## **C.2 NON-AGENCY CONSULTATION**

**RE: Weeamera Road, Culcairn – Proposed Solar Farm**

APA's updated response has been provided following review of the Preliminary Layout Plan prepared by Iberica Engineering, dated April 2019. Specifically pages 1 and 4 of the preliminary layout plan where APA's easement is outlined on Lots 54 on DP753735 and Lot 1 on DP575478 near PVs 37, 49, 54, 55, 56, and 57. APA notes the provision that all buildings including panels are located off APA's easement and inclusion of a 10-metre setback from APA's easement, which generally aligns with the proposed fencing. APA is supportive of the proposed layout subject to further review of the proposal

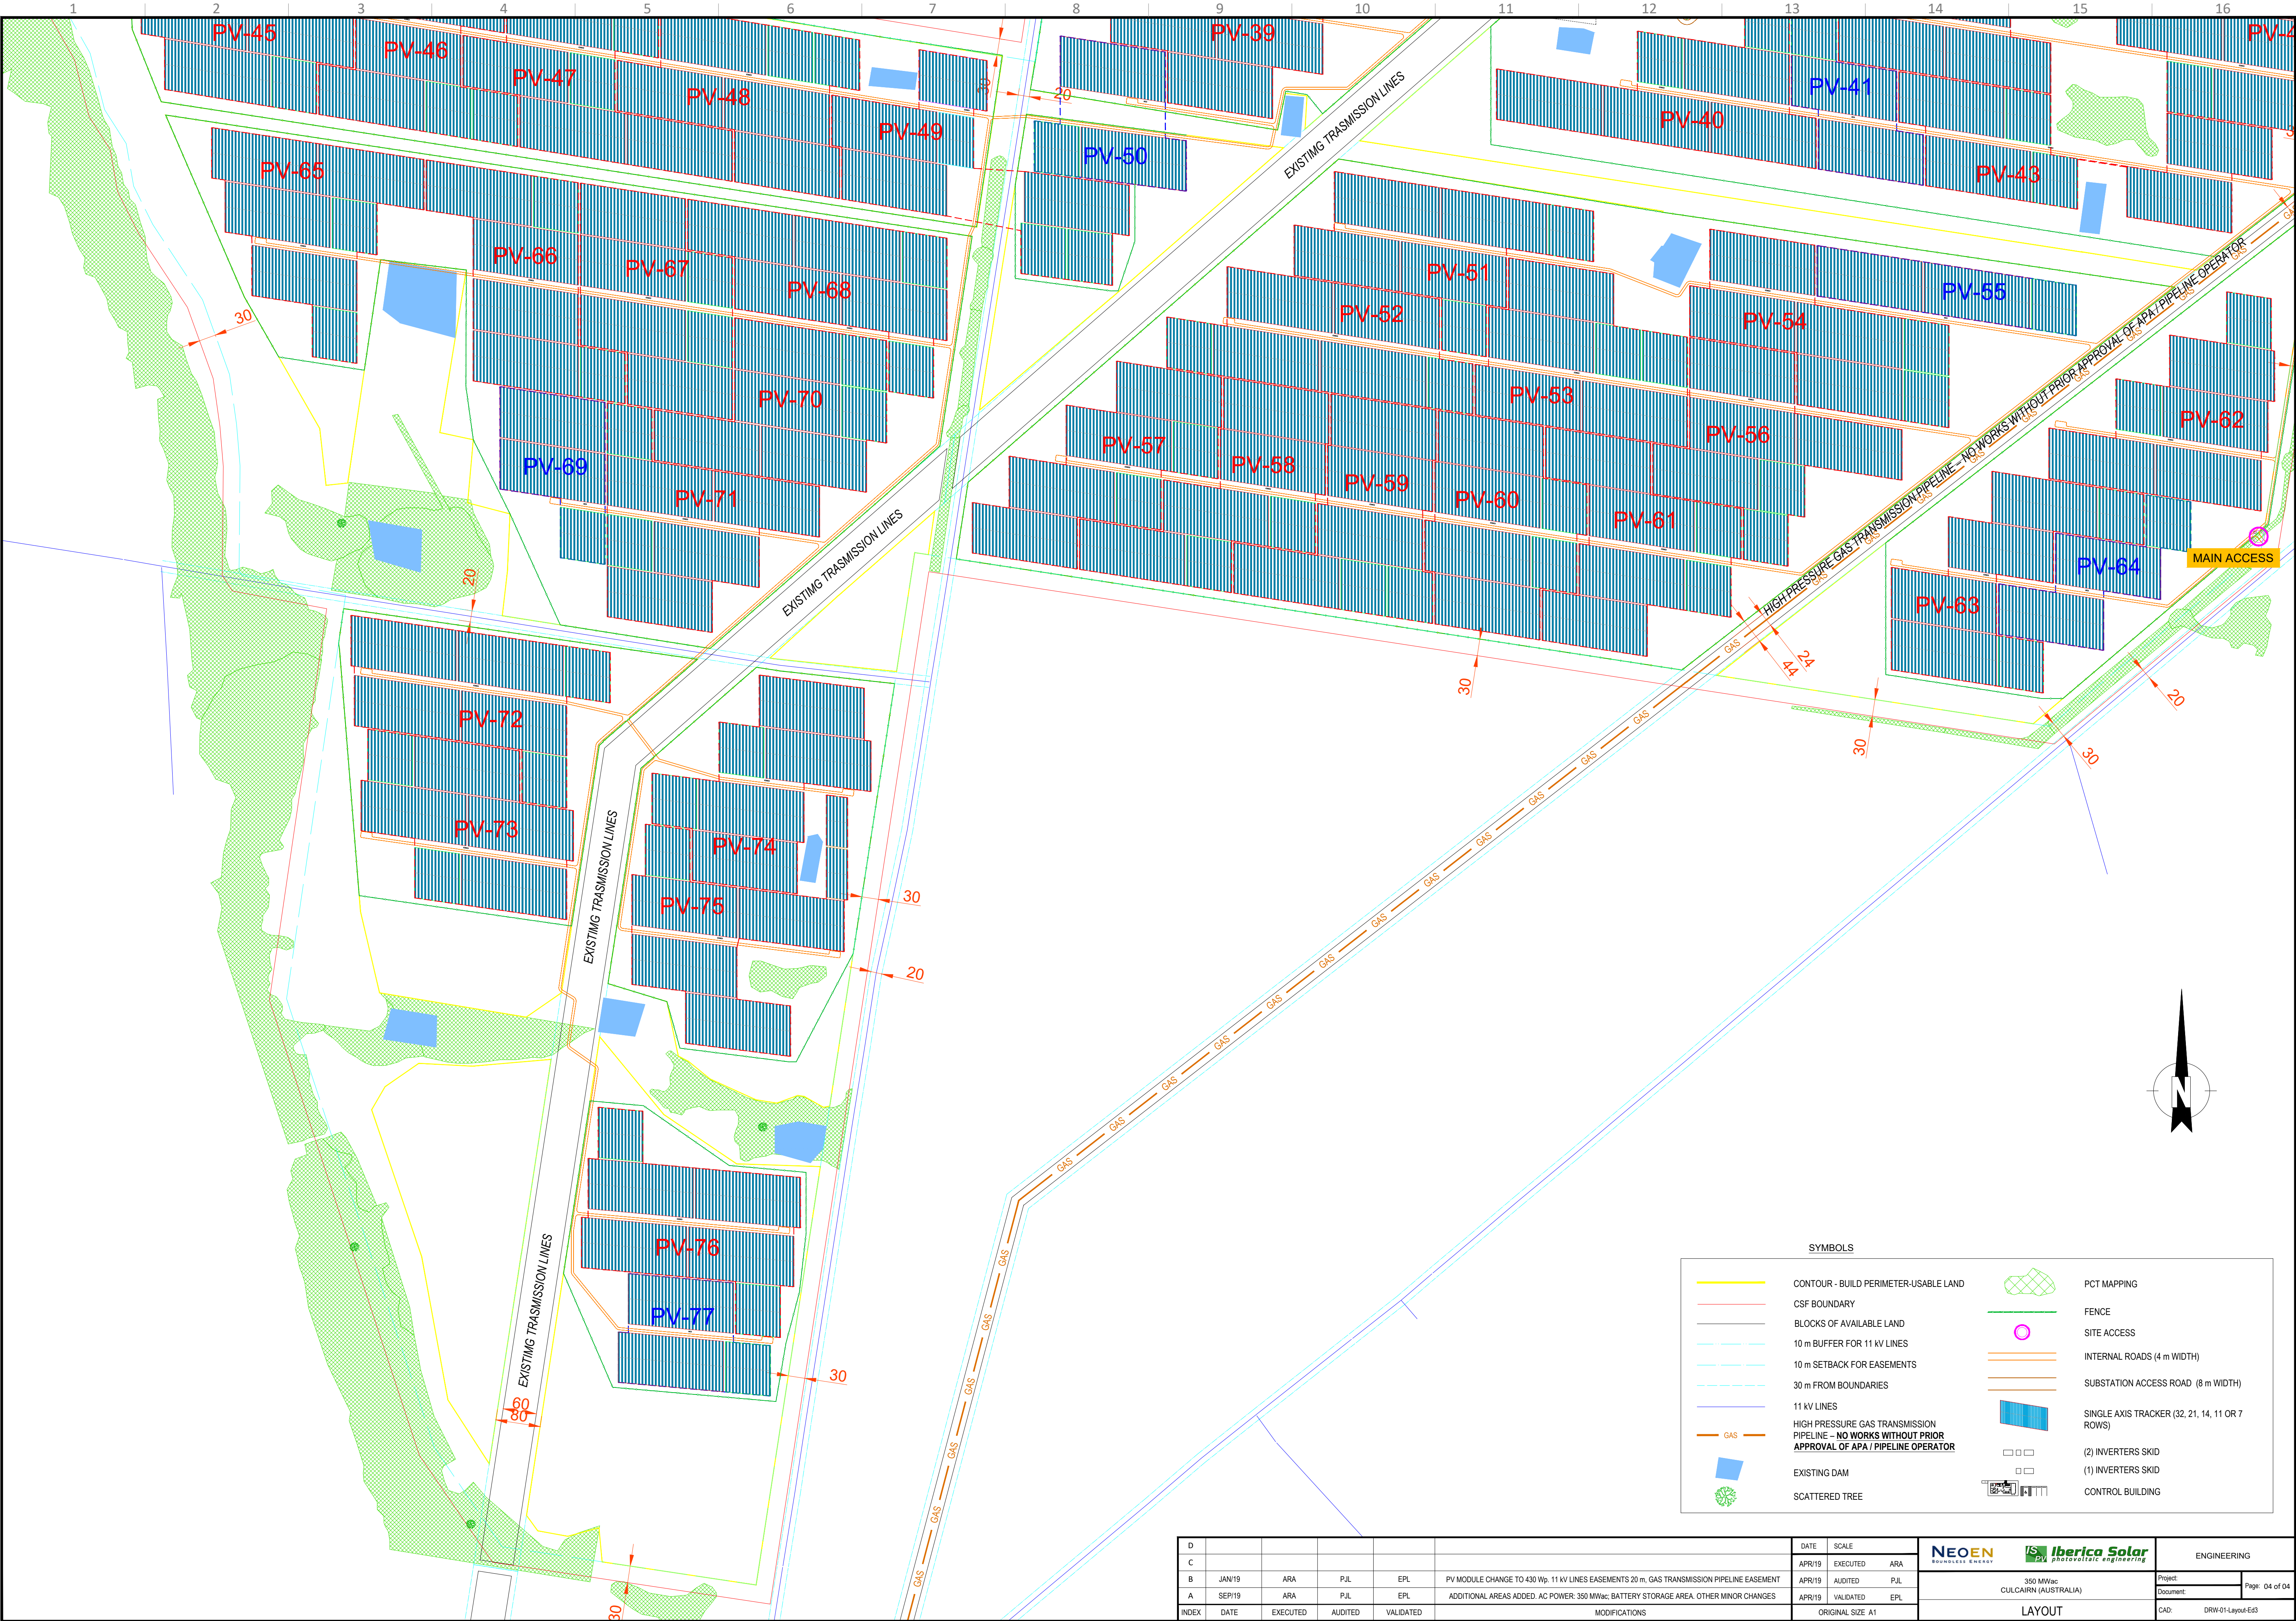
While the plans reference APA's pipeline easement, it is not clearly marked as being for a high pressure gas transmission pipeline. The level of risk associated with any intrusion into the easement is not adequately communicated to those undertaking site works. The easement should be clearly identified as an easement for a high pressure gas transmission pipeline on all relevant plans. In addition the easement should be hatched and notated as '*no works to occur without the prior authorisation of the pipeline operator*'.

Our preference is to avoid any works in the pipeline easement, including any improvements or installations. However, we are willing to accept such works necessary for the development provided they will not impact on the pipeline. Details of all proposed crossings (including roads or services) and works within the easement, must be submitted to APA for consideration. No crossings may occur without the prior authorisation of APA, and must be completed in accordance with any conditions imposed by APA. This includes changes in ground level on the easement, change in stormwater flows over the easement, and storage of equipment.

Crossings of underground services must accord with APA requirements, particularly minimum separation distances. Road crossings for heavy vehicles (as expected to be required in this case) will require a concrete slab crossing to disperse loads on the pipeline to an acceptable level. This will need to be designed to APA requirements. Vehicular crossings during construction and operation will need be at the agreed crossing points.

All proposal plans must clearly show APA's pipelines and easement, labelled as 'high pressure gas transmission pipelines – no works without prior approval of APA'.

The proposed development is expected to have significant areas of panels to both the north and south of the pipeline easement, and there is anticipated to be the need for crossings of the pipeline. These include:

APA seeks to minimise the number of crossings and have these perpendicular to the pipeline if possible. This should include the co-location of road and services crossings. No work on the easements, including crossings, changes in ground level or other works, may occur without the prior authorisation of APA. Detailed design for crossings will need to be informed by field works to positively locate the pipeline (alignment and depth). Such field works must only be performed under APA permit.

Buildings, structures, roadway, pavement, pipeline, cable, fence, on-site waste water treatment (or irrigation area), or any other improvement on or under the land within the gas transmission pipeline easement must not be constructed without prior consent in writing from APA. No structure or vegetation will be permitted on the easement that prohibits maintenance of line of sight along the pipeline easement.

All plans which include the area of the gas pipeline easement must have the easement clearly identified with hatching on the full width of the easement. The easement must also be clearly labelled as *'high pressure gas pipeline easement – no works to occur without the prior authorisation of the pipeline operator'*.
